Suffolk County Council (20041323)

Preliminary Ideas for Additional Strategic Planting in Suffolk

Bramford to Twinstead (EN020002)

Deadline 6

STOUR VALLEY WEST SEALING END COMPOUND: PLAN VIEW  
 SCALE 1:200

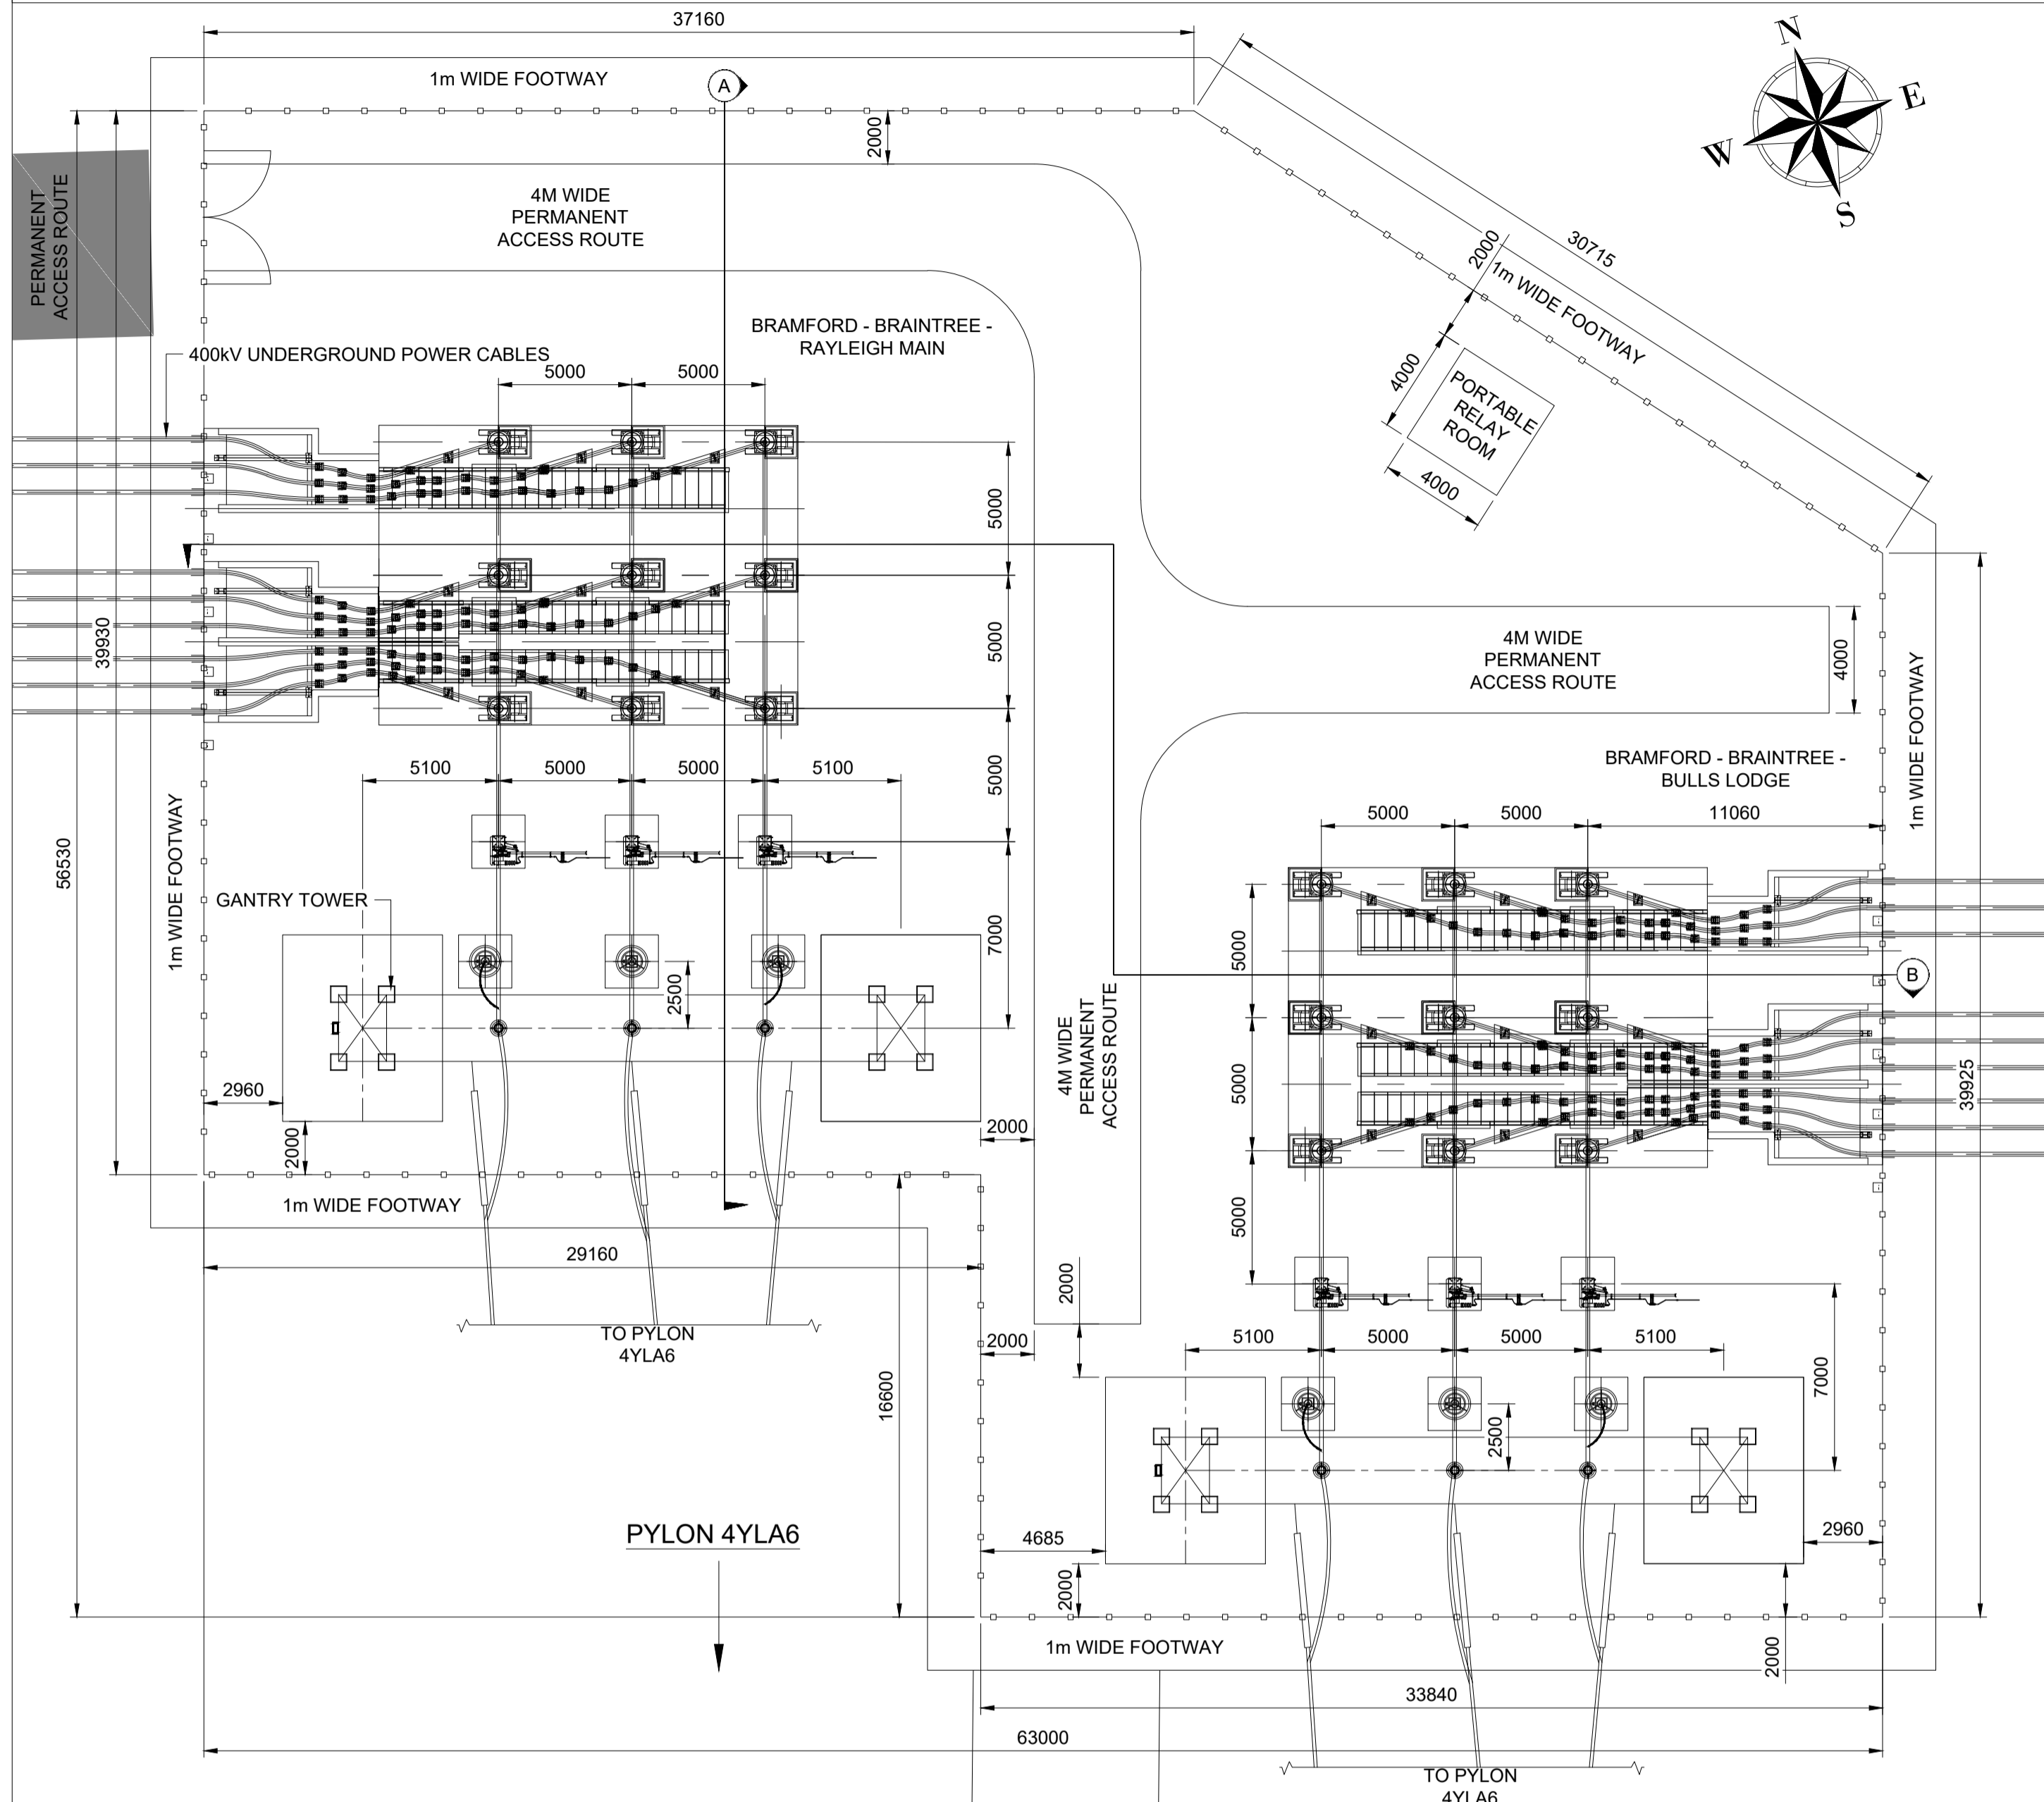
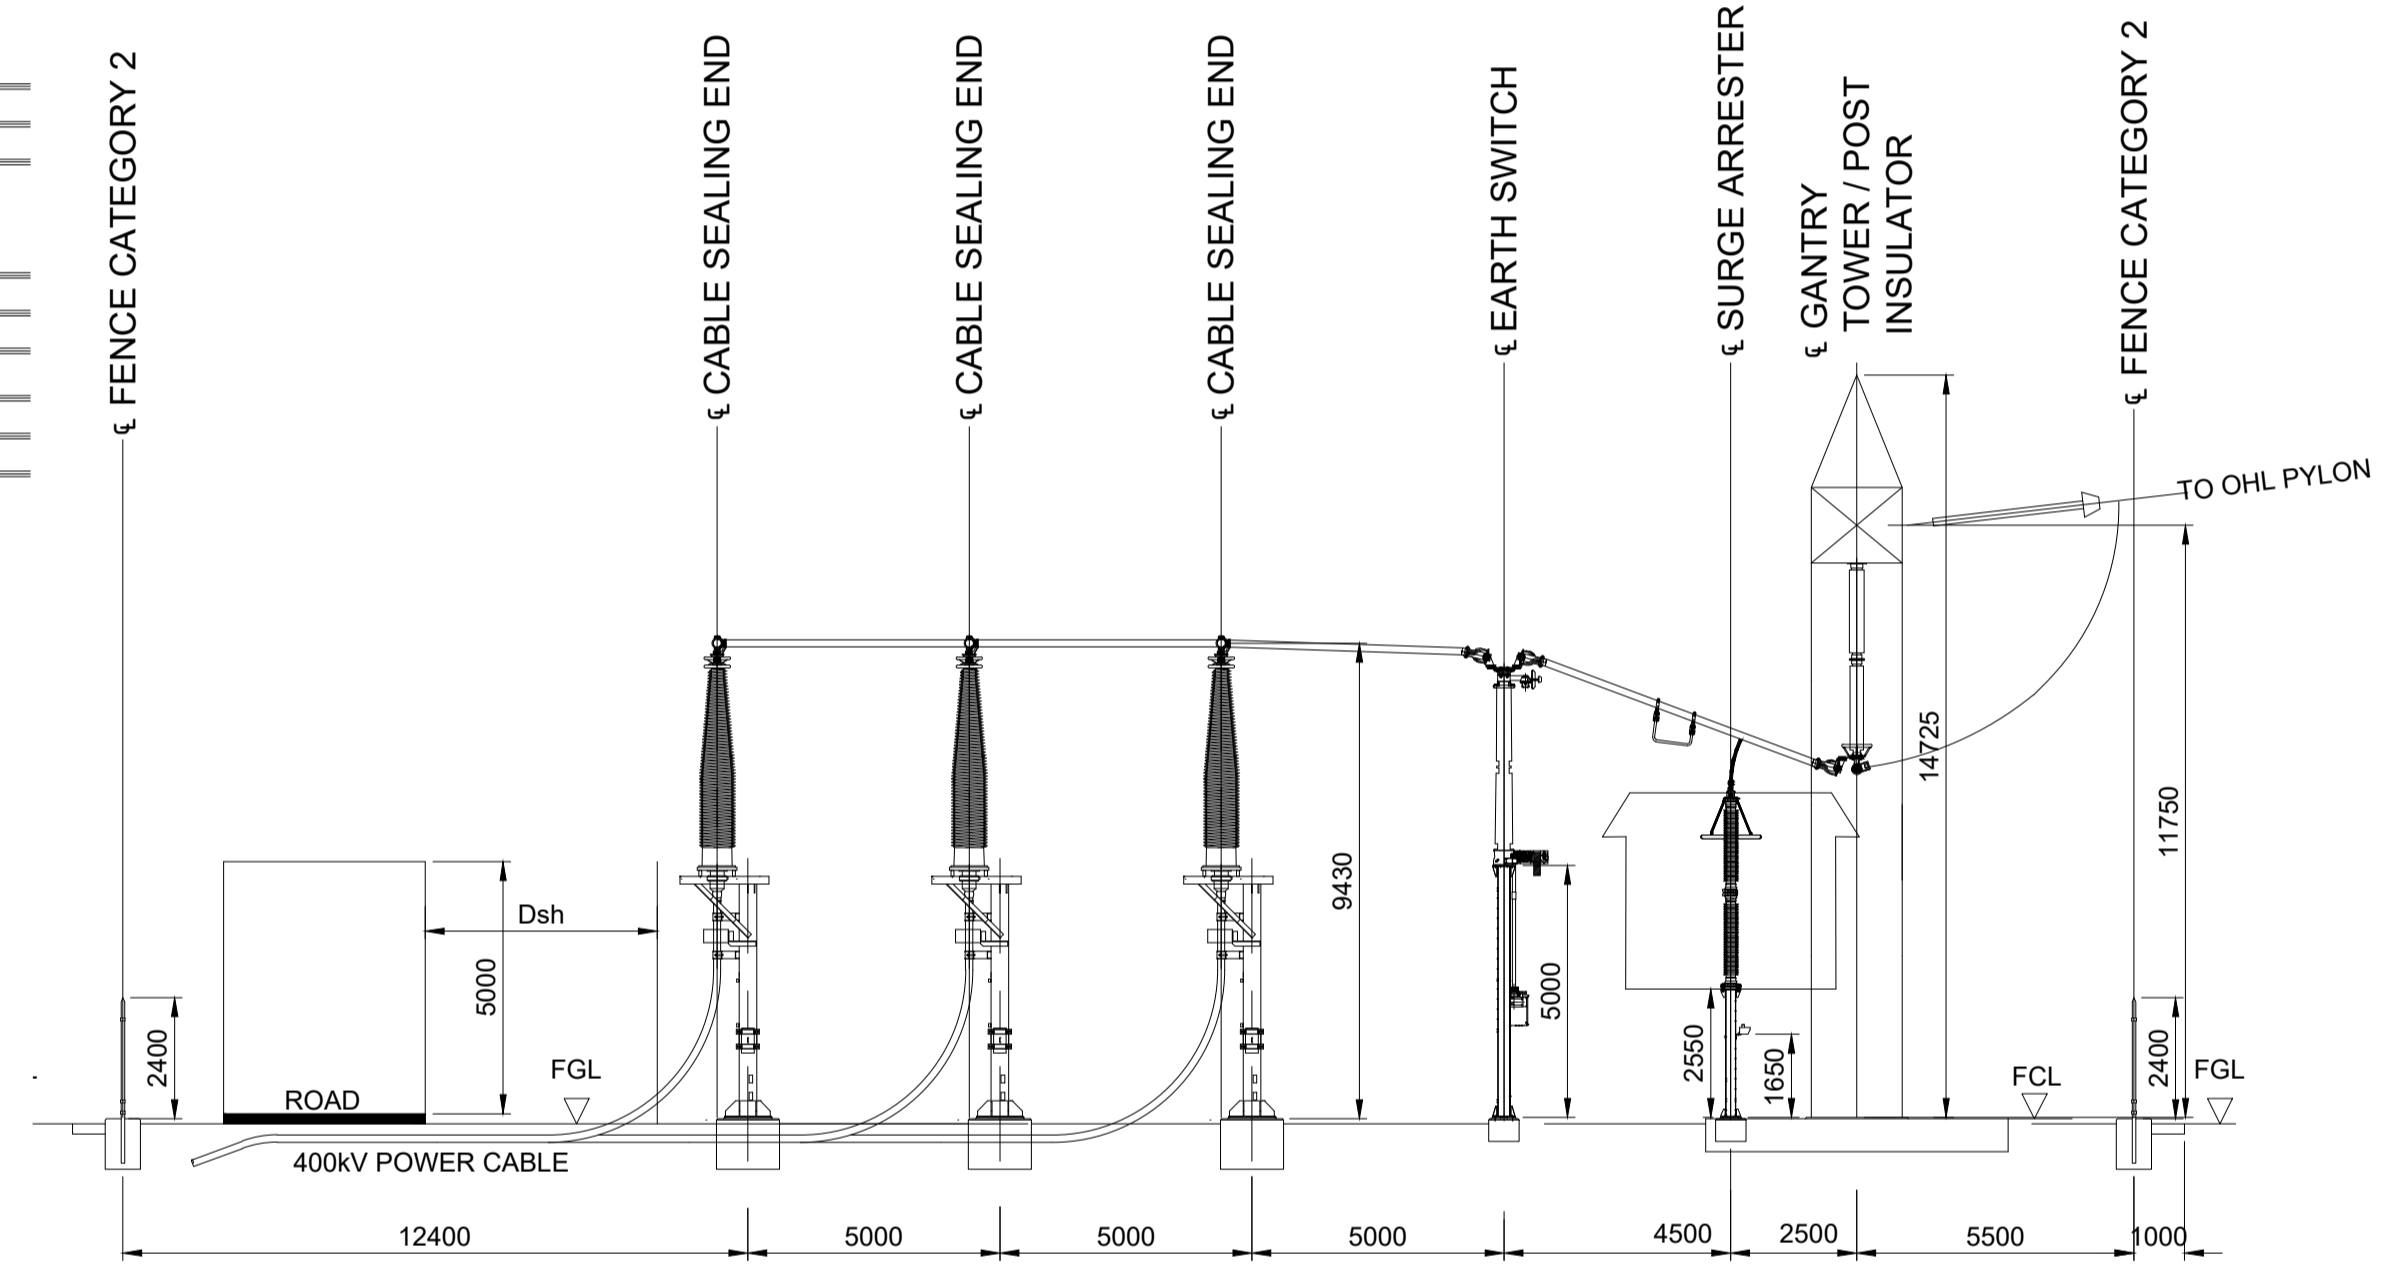
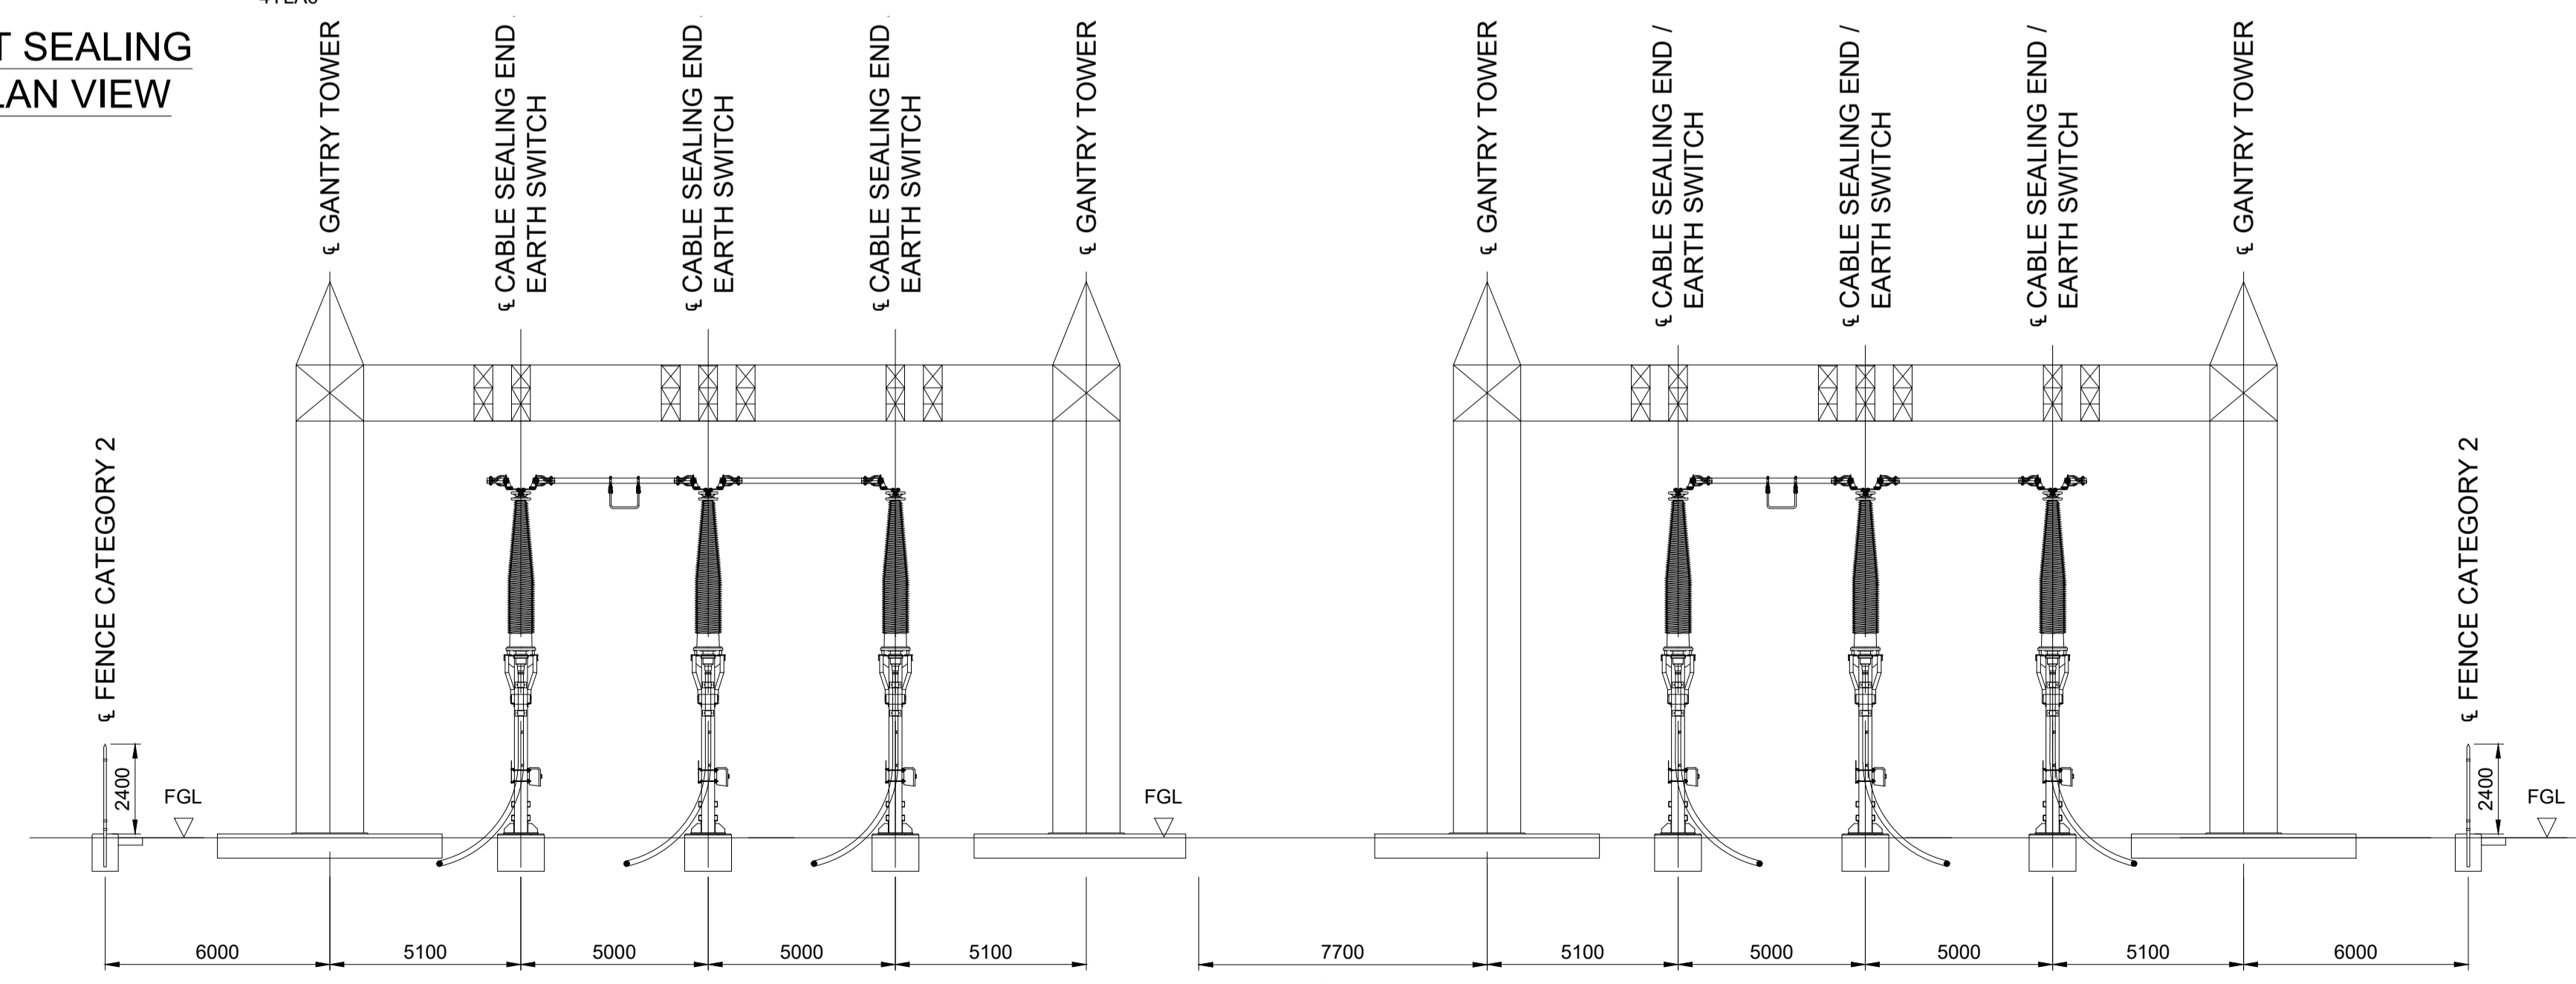
Viewpoint Ref.	Viewpoint Title	Requests for additional strategic planting (not comprehensive)	Mitigation (M) Compensation (C) Community Benefit (CB)
G01 (Photomontage 29)	PRoW near Dorking Tye House	<ul style="list-style-type: none"> • This is an area, where the adverse visual effects are significant. • Strengthen the vegetation on the northern side of the PRoW, including hedgerow trees. • To reduce visual clutter in this area, underground telegraph post along the lane, and manage roadside hedge for additional filtering of the views. • This area should be considered for wider landscape restoration. 	M M C
G07 (Photomontage 34A, 34B)	PRoW near Mabb's Corner	<ul style="list-style-type: none"> • The vegetation reinstatement plan (Sheet 28) does quote EM-G06: the design allows for an area of landscape planting around the CSE compound at Stour Valley West. The embedded planting will be maintained for the life of the CSE compound. • The Photomontage does not show any difference in screening between years 1 and 15; there appears not mitigative planting; this is insufficient; please provide screen planting proposals for the CSE compound.
